# CITY OF ALBUQUERQUE

**Re: WELLS PARK COMMUNITY CENTER ADDITIONS AND  
ALTERATIONS, (J-14/D26)**  
**500 Mountain Road NW**  
**Permanent Hydrology Certificate of Occupancy, Submitted 06/05/2006,**  
**Certification dated 06/02/2006**

Based upon the information provided in your submittal received 06/02/2006, the  
above referenced Certification cannot be approved until the following is addressed:

TITLE: WELLS PARK COMMUNITY CENTER ADDITIONS & ALTERATIONS
GRADING AND DRAINAGE PLAN

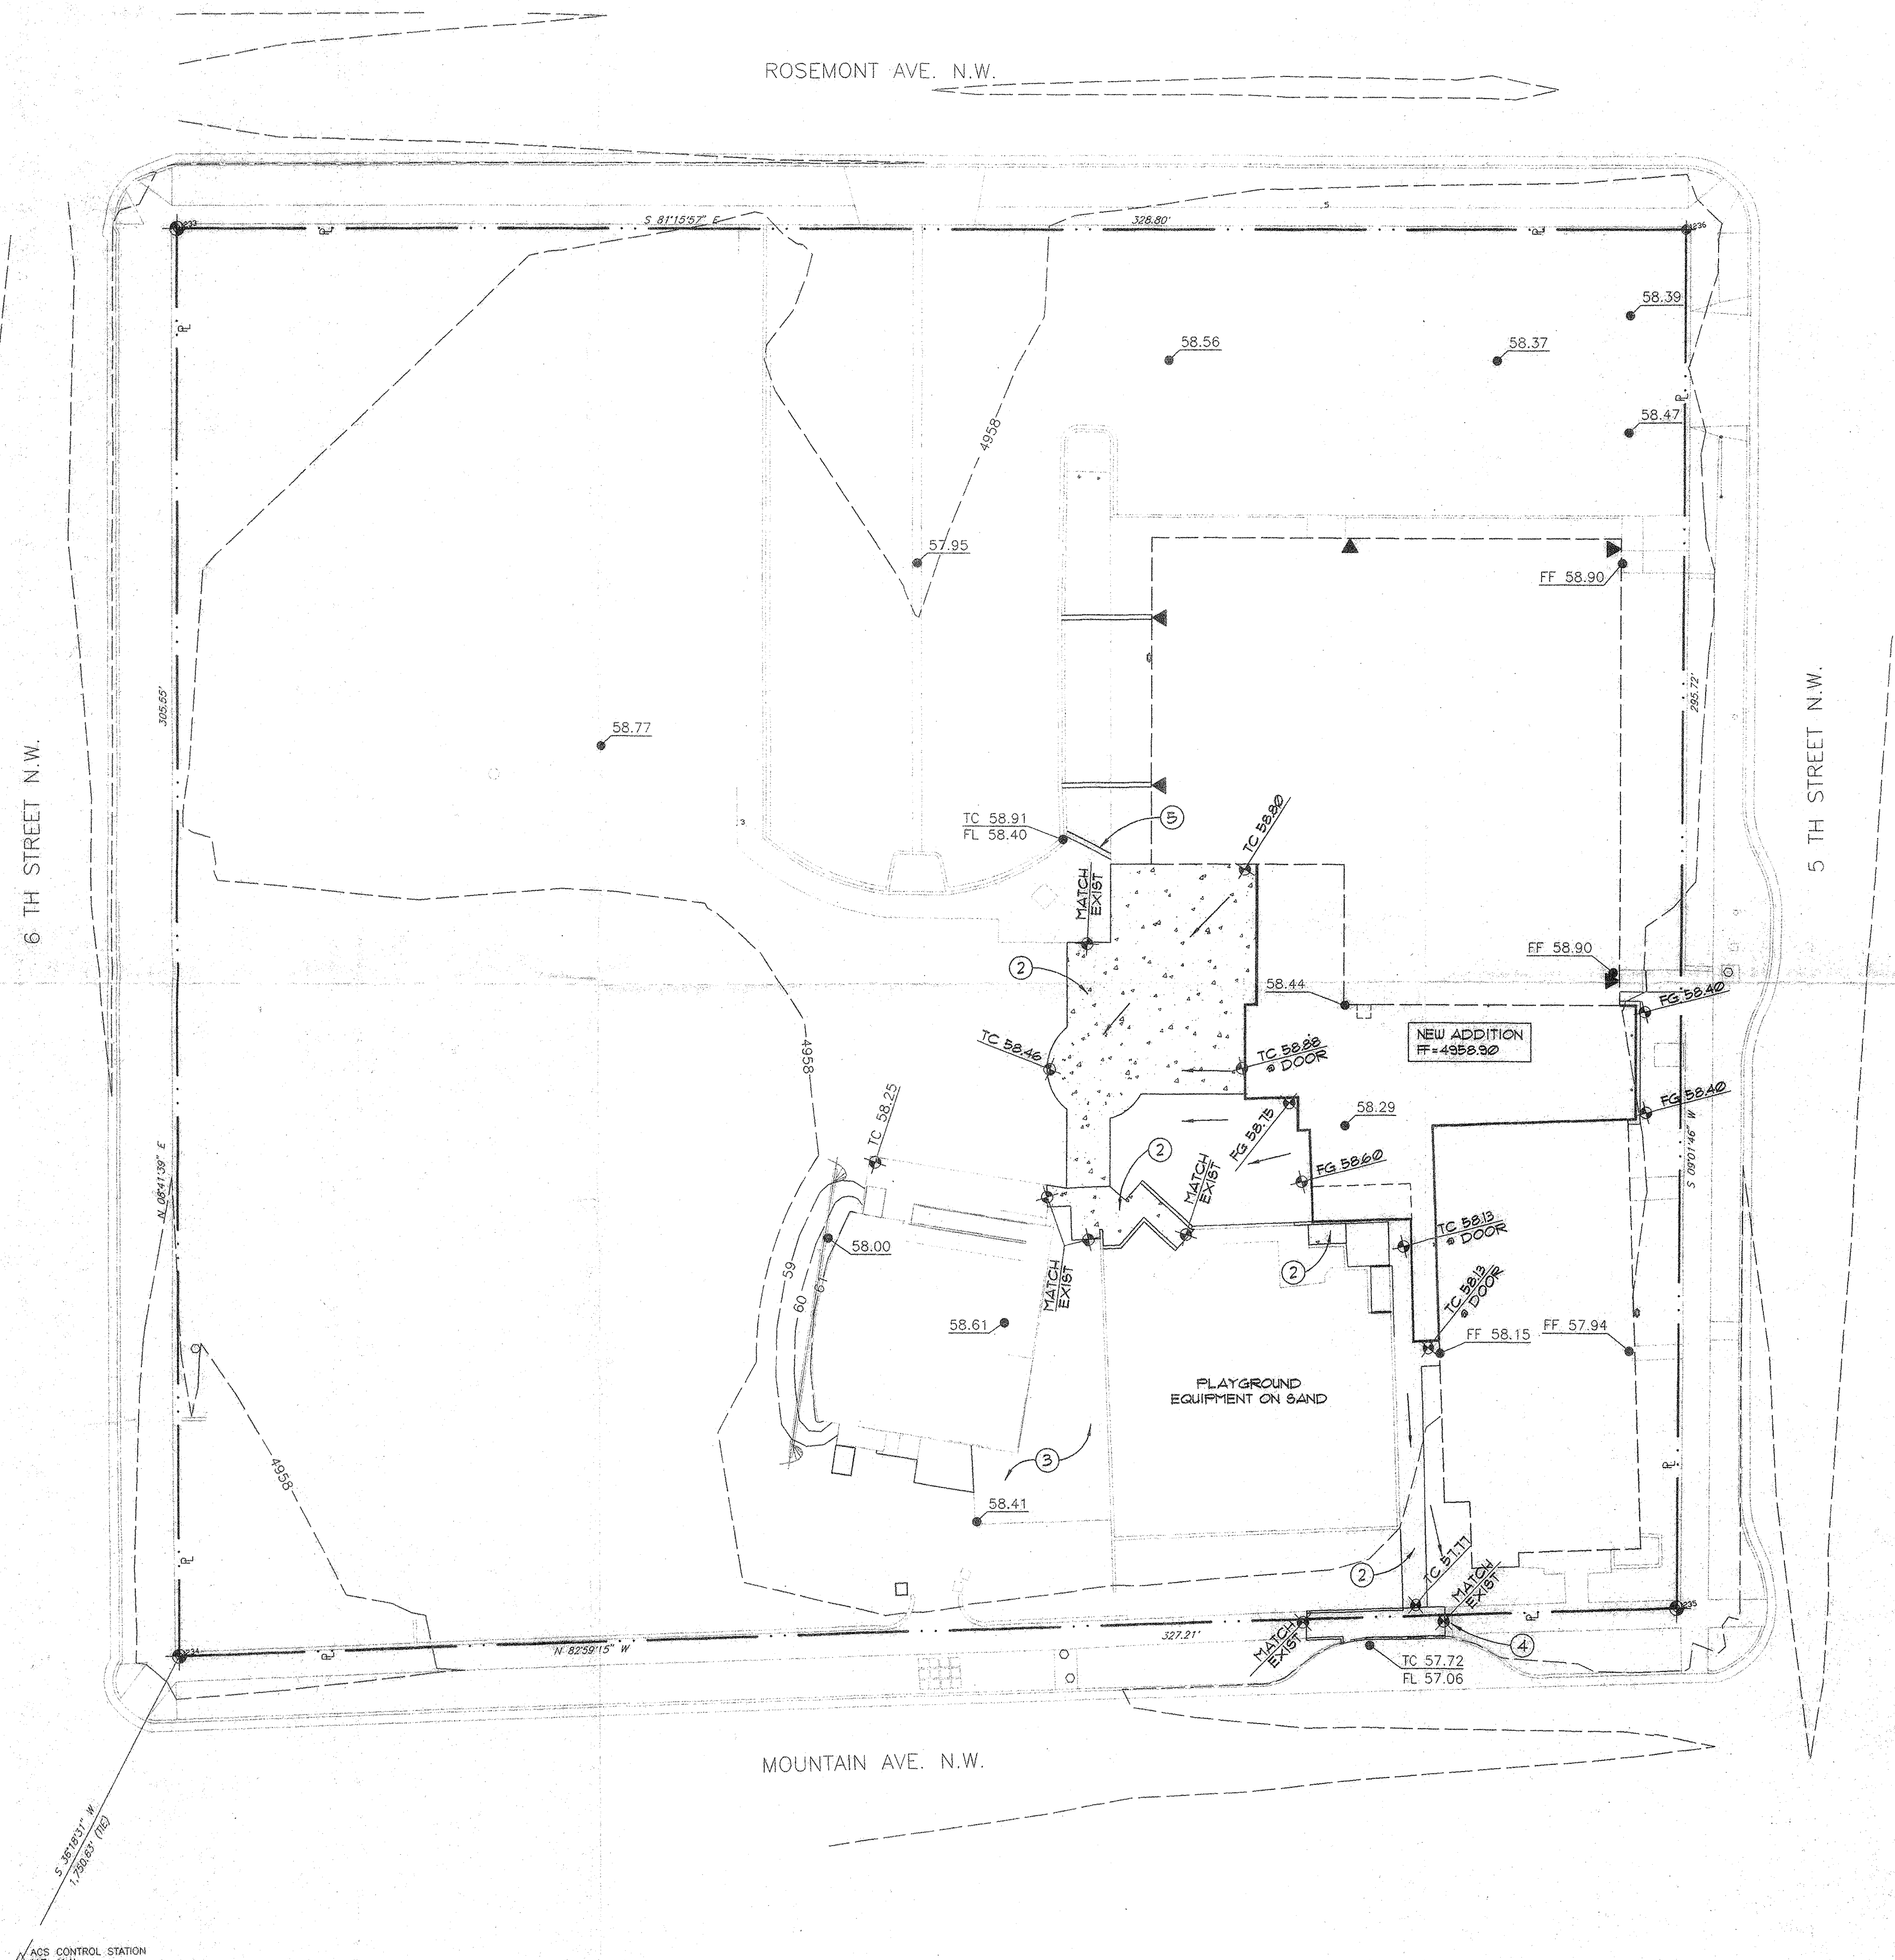
1. The approved Grading and Drainage (G/D) Plan has an Engineer Stamp  
date of 04/19/2002 not 09/15/2004 as indicated in your submittal. Attached  
is a copy of the G/D approval letter and a copy of the bottom right hand  
corner of the approved G/D Plan.
